Submission of a Non-Material Amendment to Planning Permission Ref: 20/P/01273 at 20 The Street, West Horsley, Leatherhead, KT24 6AX

We hereby submit a non-material amendment (S96a) to amend condition 1 of the approved development, under application ref: 20/P/01273.

Drg No: **FD 19 - 1756 - 113**

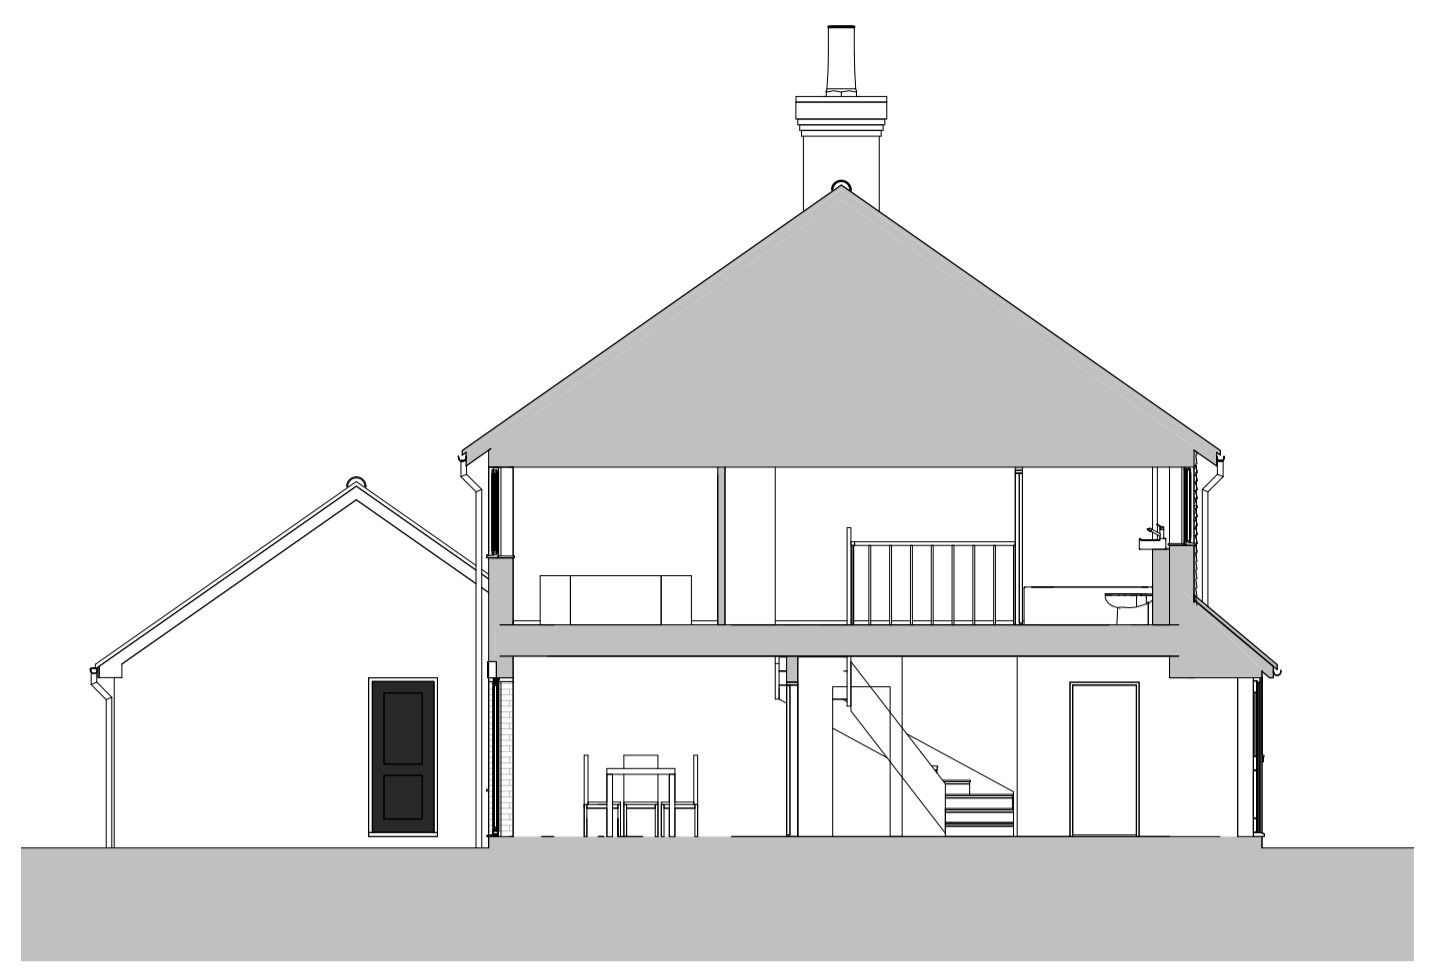
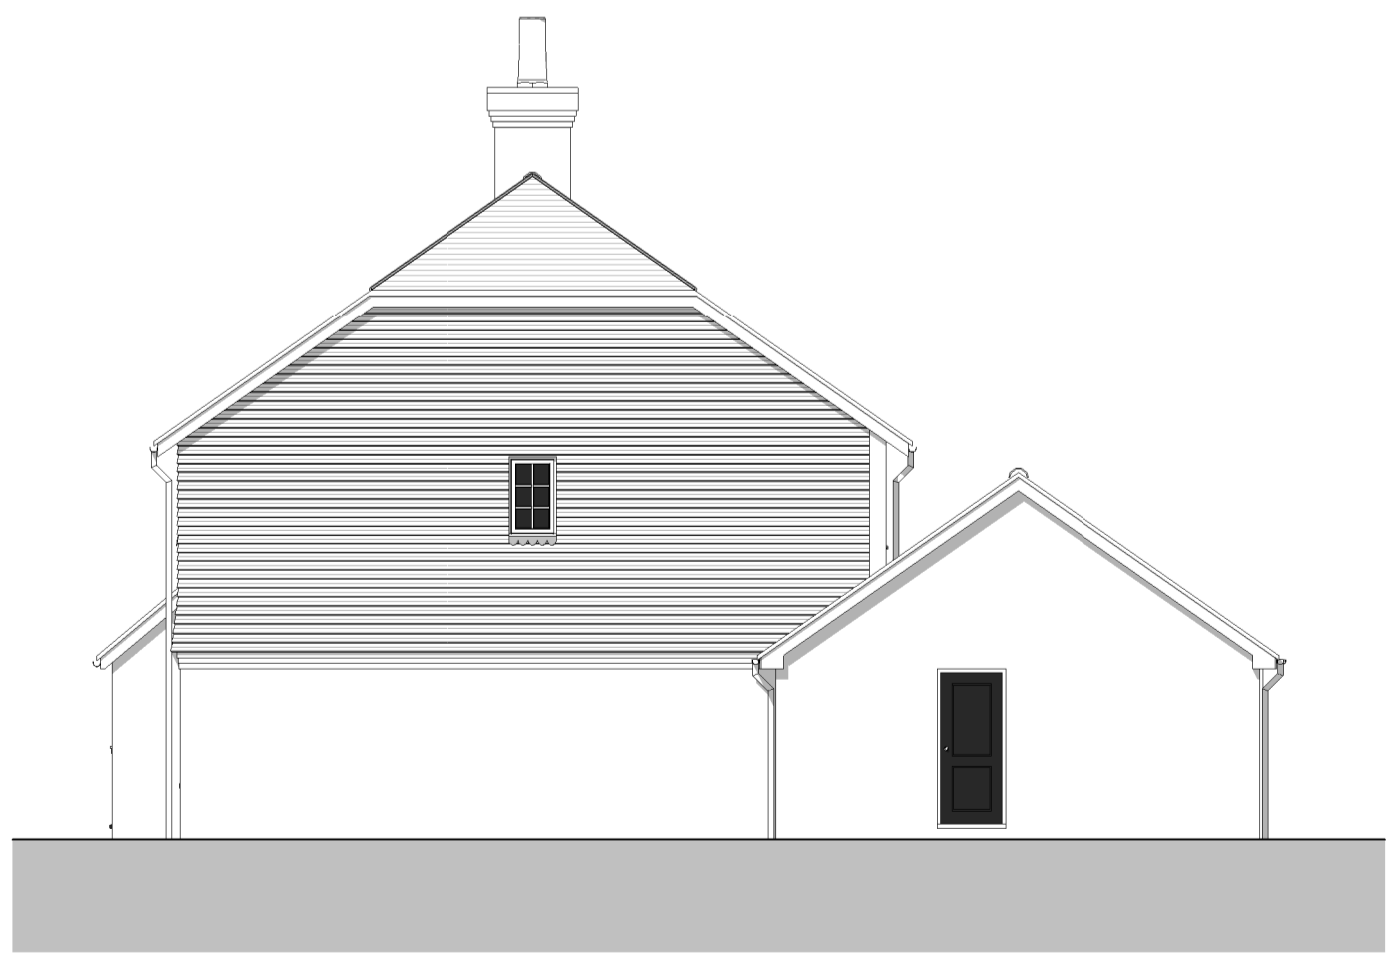
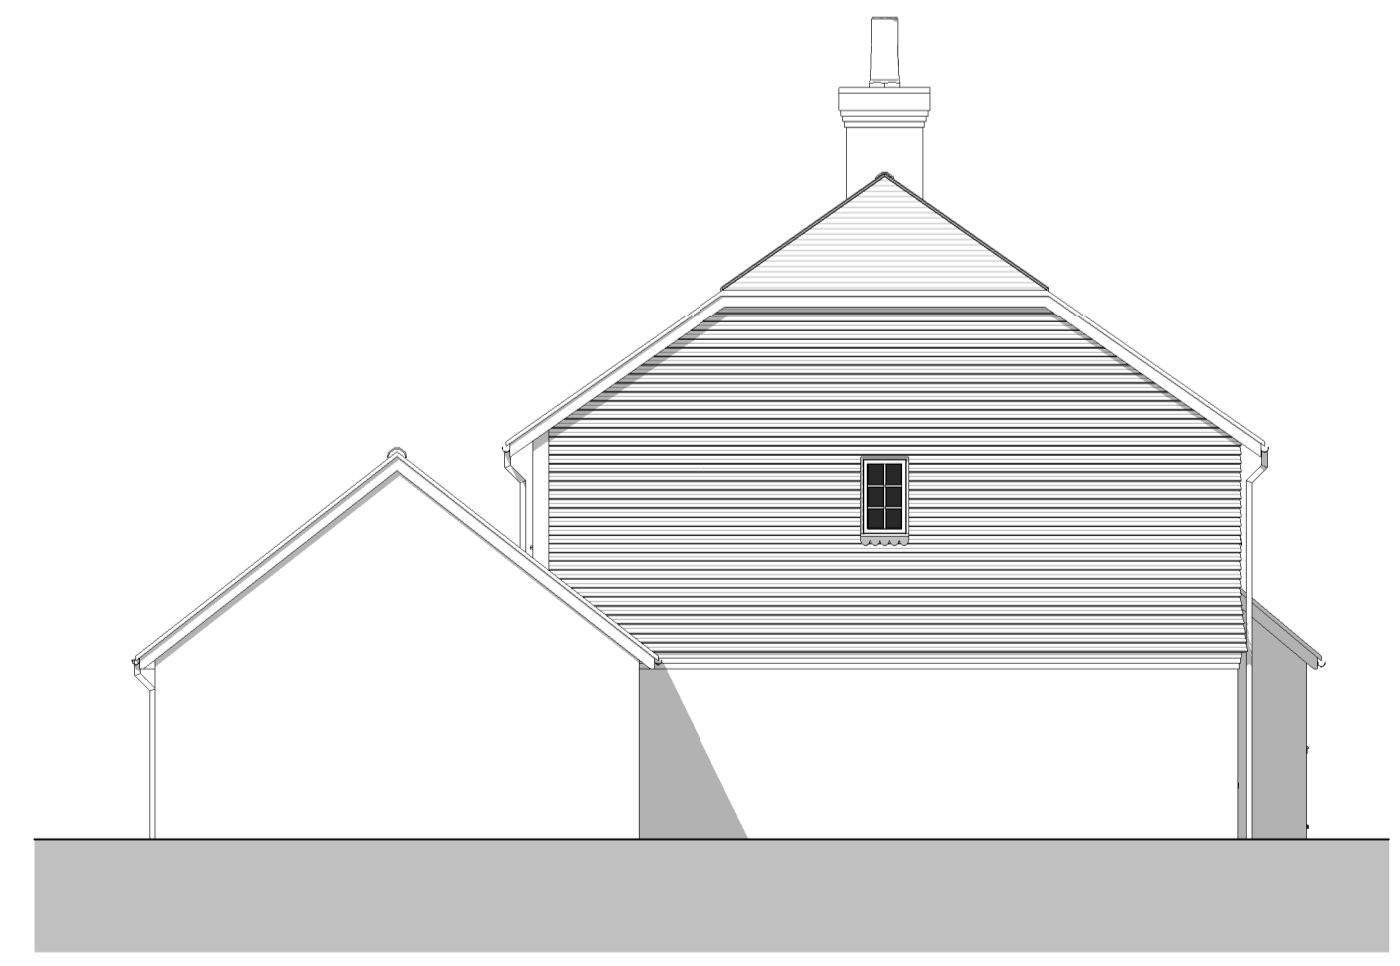
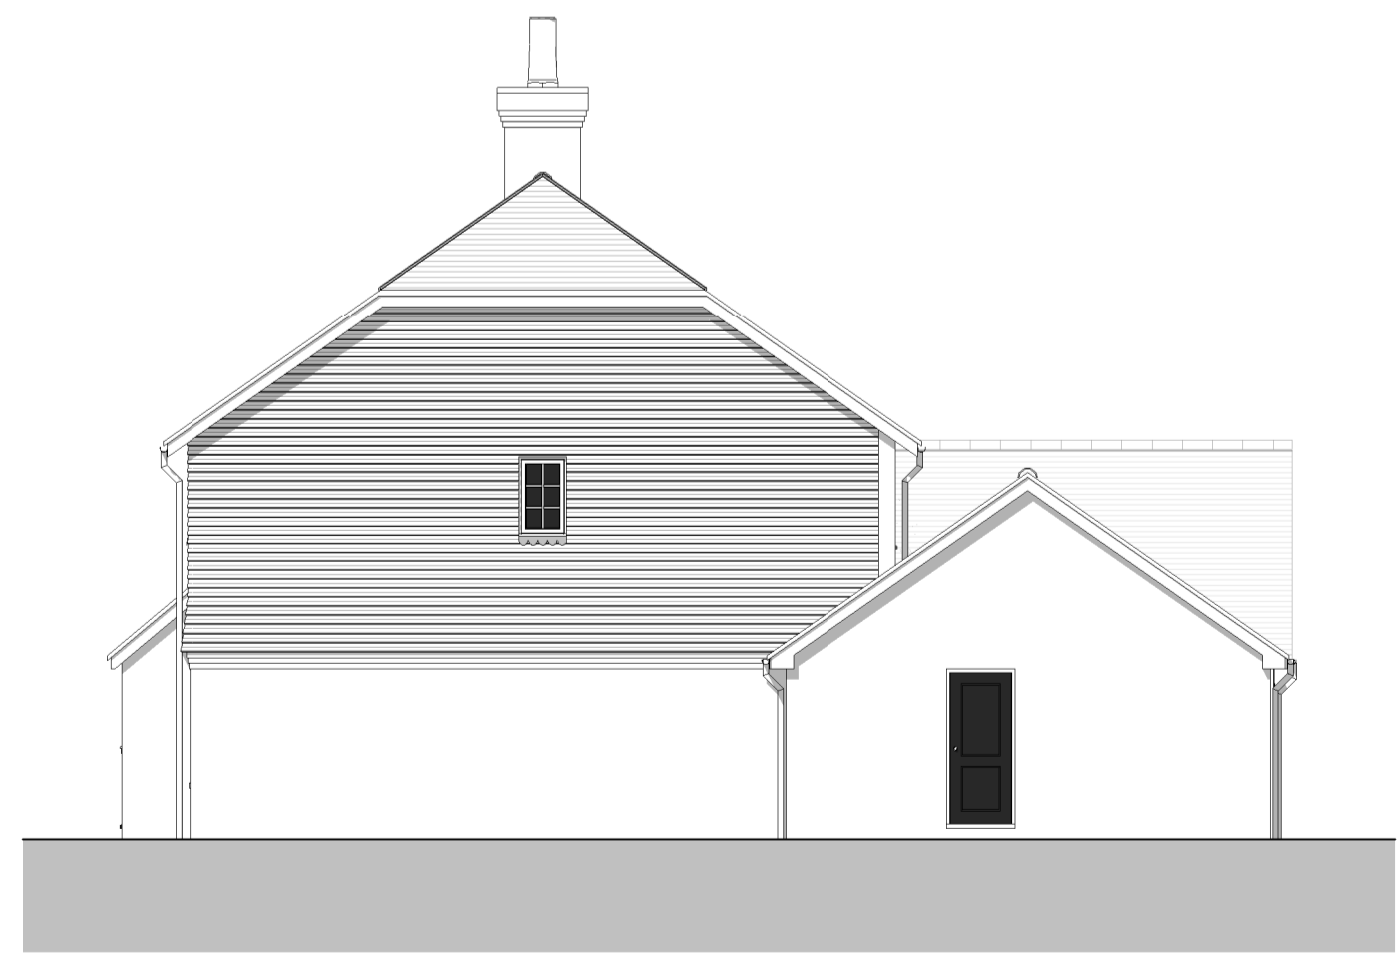
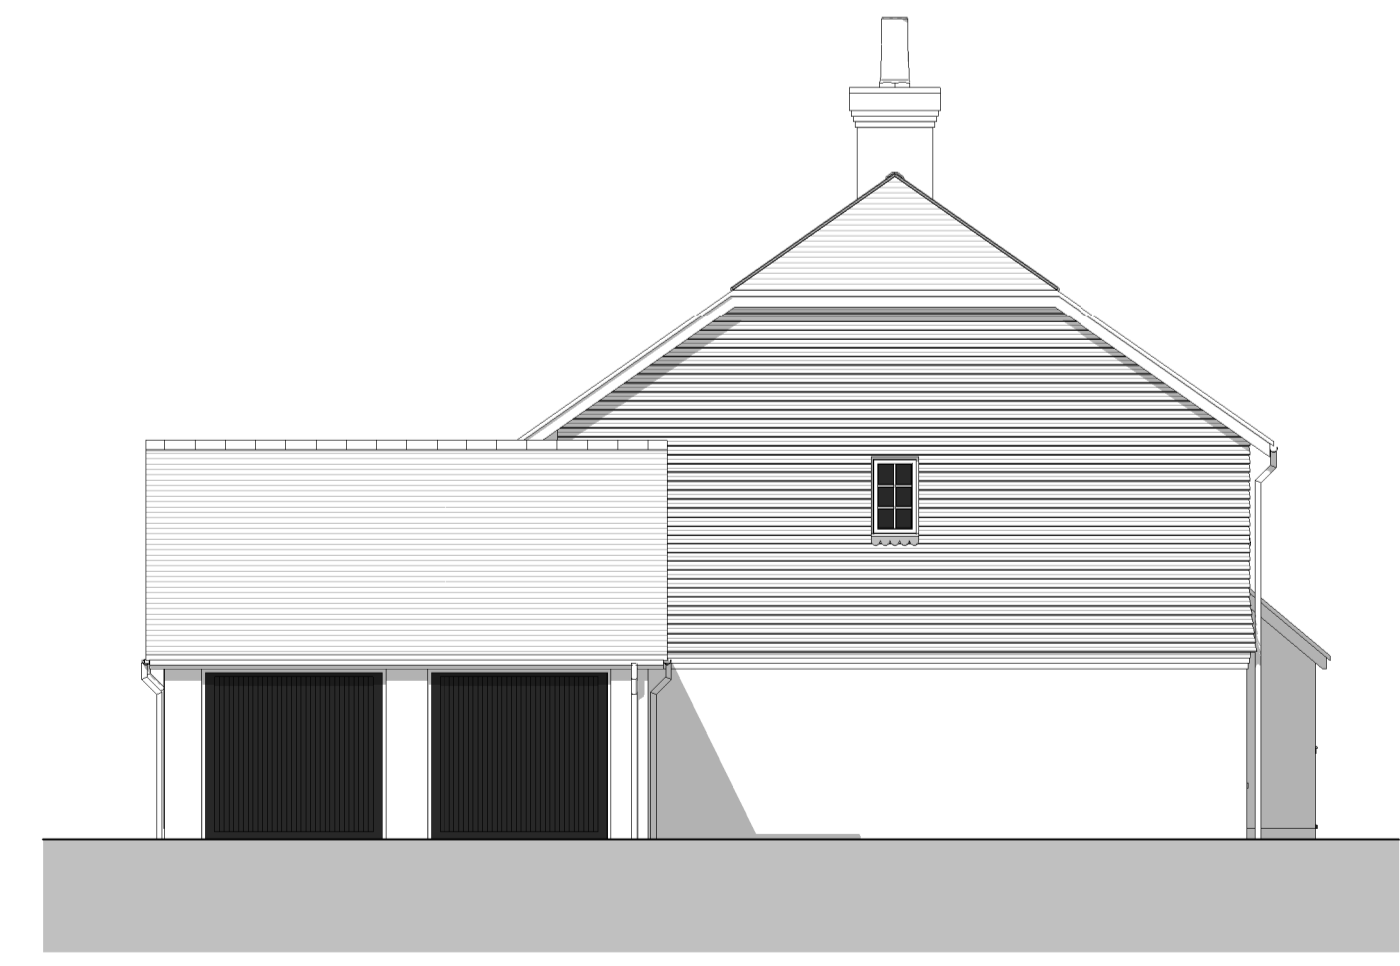
This amendment seeks only to relocate the double garage at plot 12, to adjoin the garage at plot 13. There is a legal covenant through the garden and driveway of plot 12 that restricts built structure in that area, therefore the location of the garage needs to be moved, so it falls outside this area.
